DeYOUNG SUBDIVISION Construction Drawings El Paso County, Colorado

PCD PROJECT NO. MS-20-001

TITLE SHEET

PHASE 1 - SITE GRADING & EROSION CONTROL PLAN

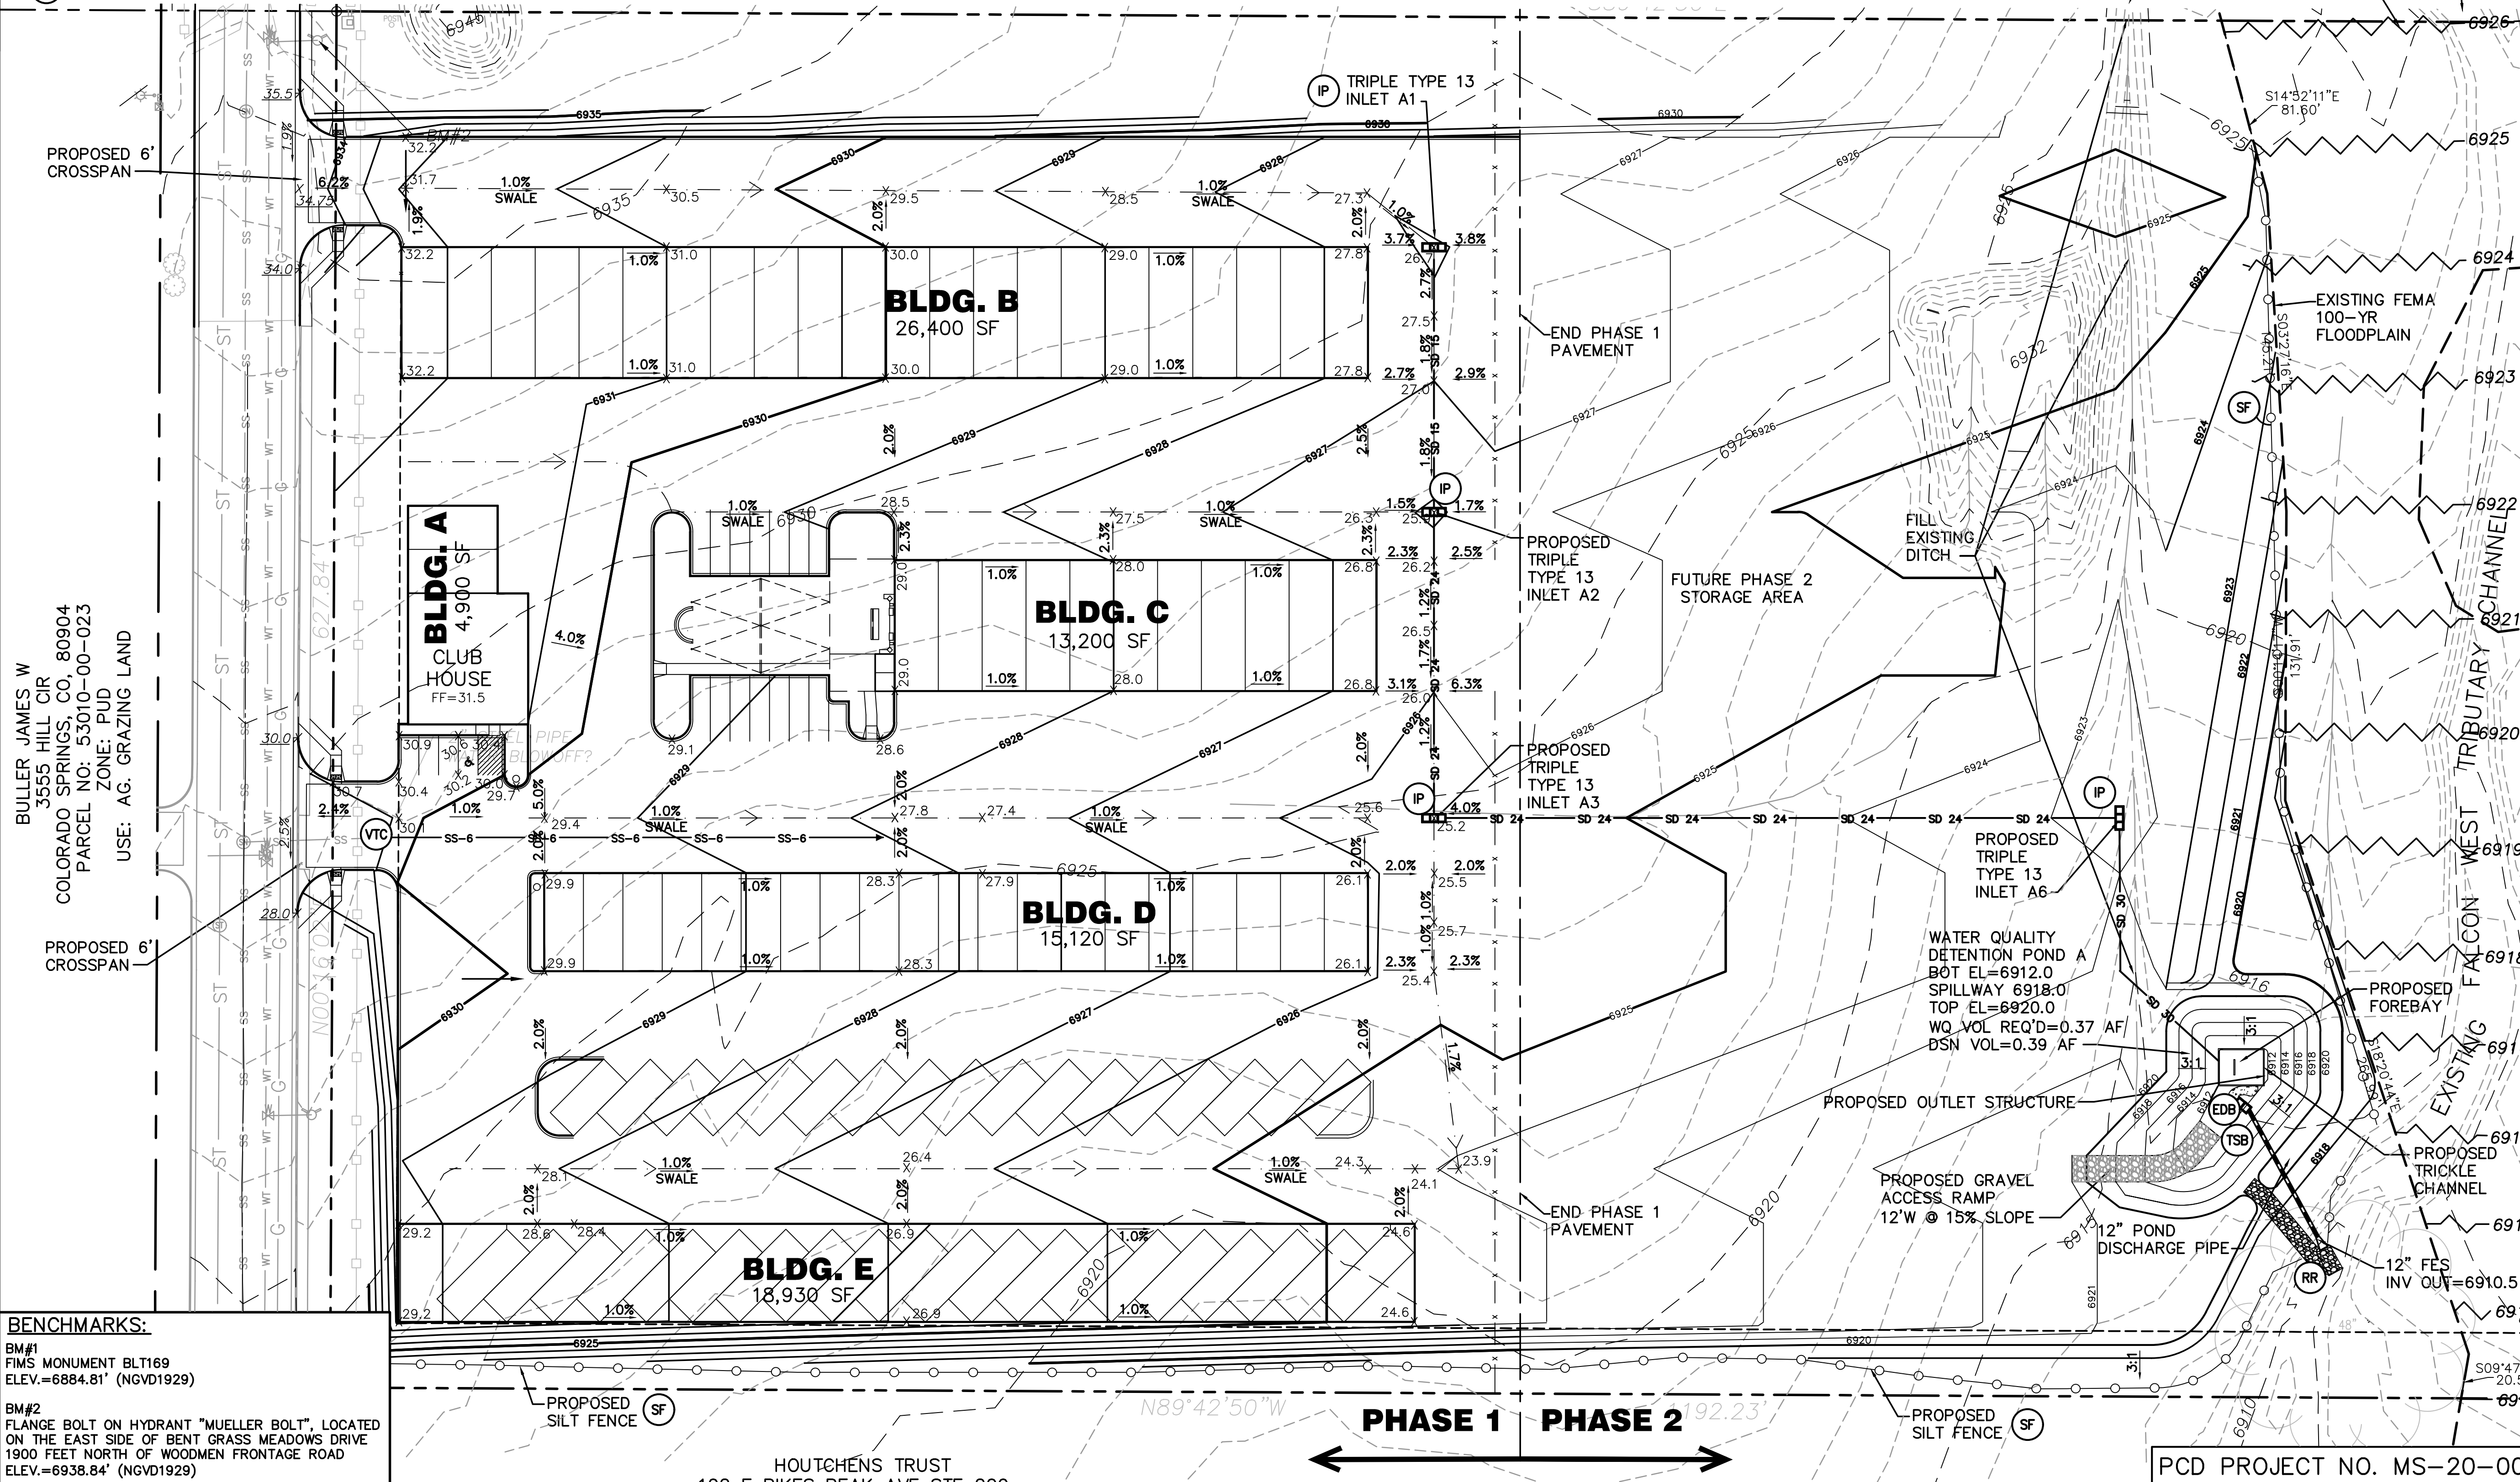
Include cul-de-sac area.

How does this area drain? Is it a TSB?

See comment on the drainage report concerning this drainage swale.

See comments on CD sheet regarding spillway.
